Application for a non-material amendment following a grant of planning permission.  
 Town and Country Planning Act 1990

Single storey front & rear extension, garage conversion and internal alterations.

23/00124/FUL

Reconfiguration of the internal layout and inclusion of 3.0m bi fold doors in the new living room.

Title :
ELEVATIONS
AS PROPOSED

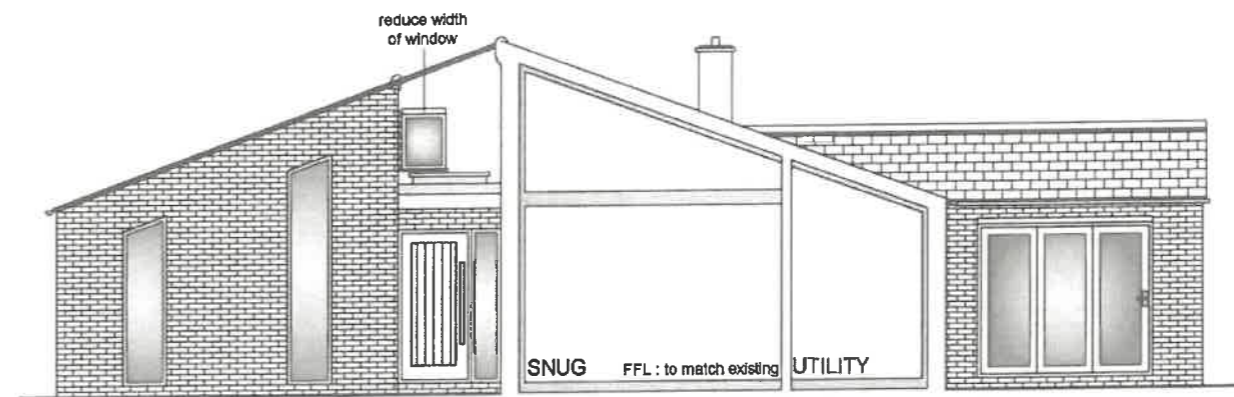
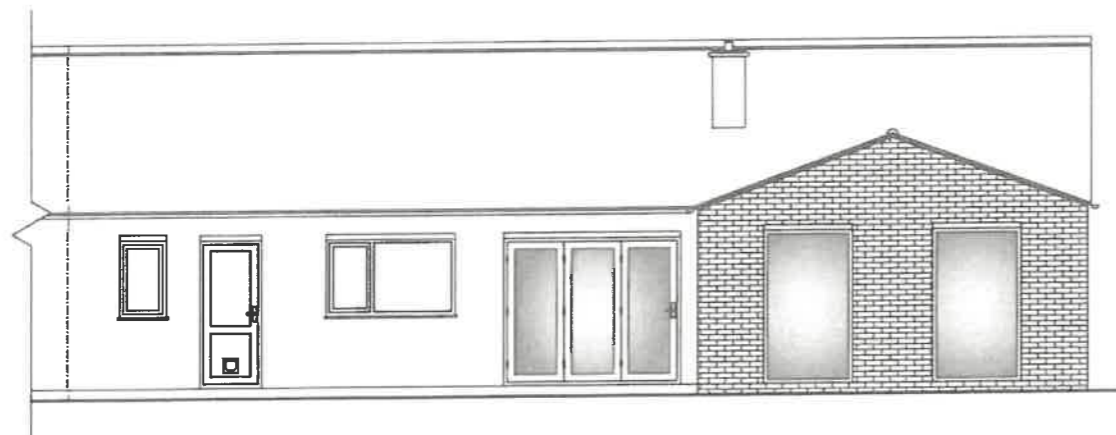
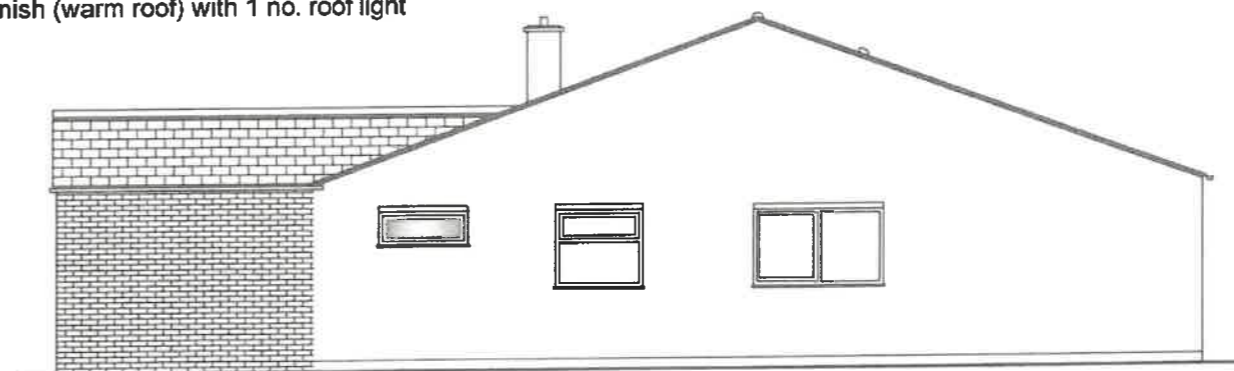
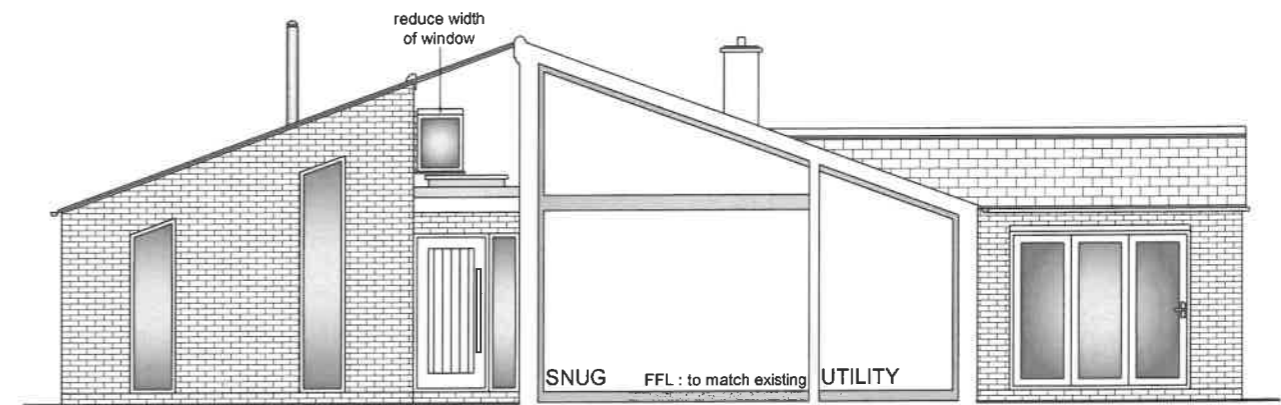
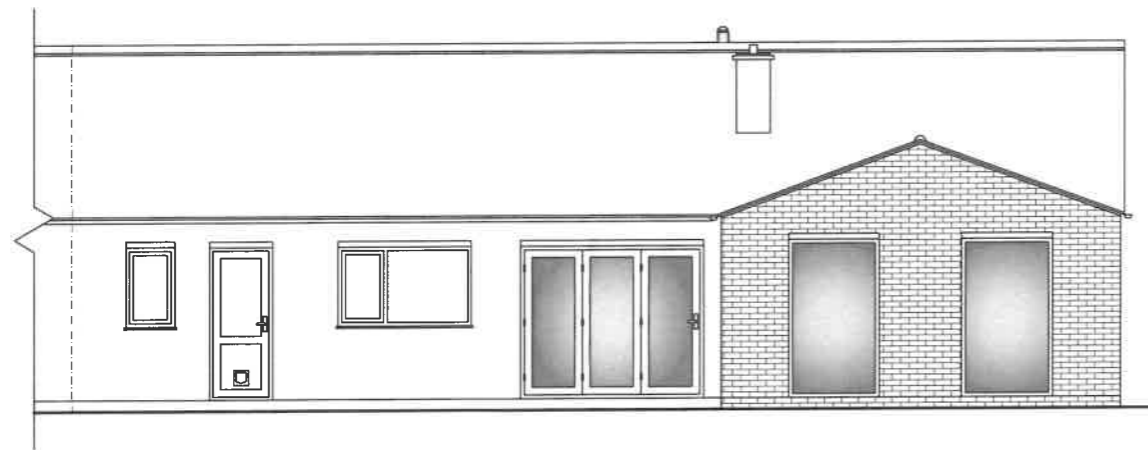
05/3021/22 ; 06/3021/22 ; 07/3021/22 ; 08/3021/22

05/3021r/22 ; 06/3021r/22 ; 07/3021r/22 ; 08/3021r/22
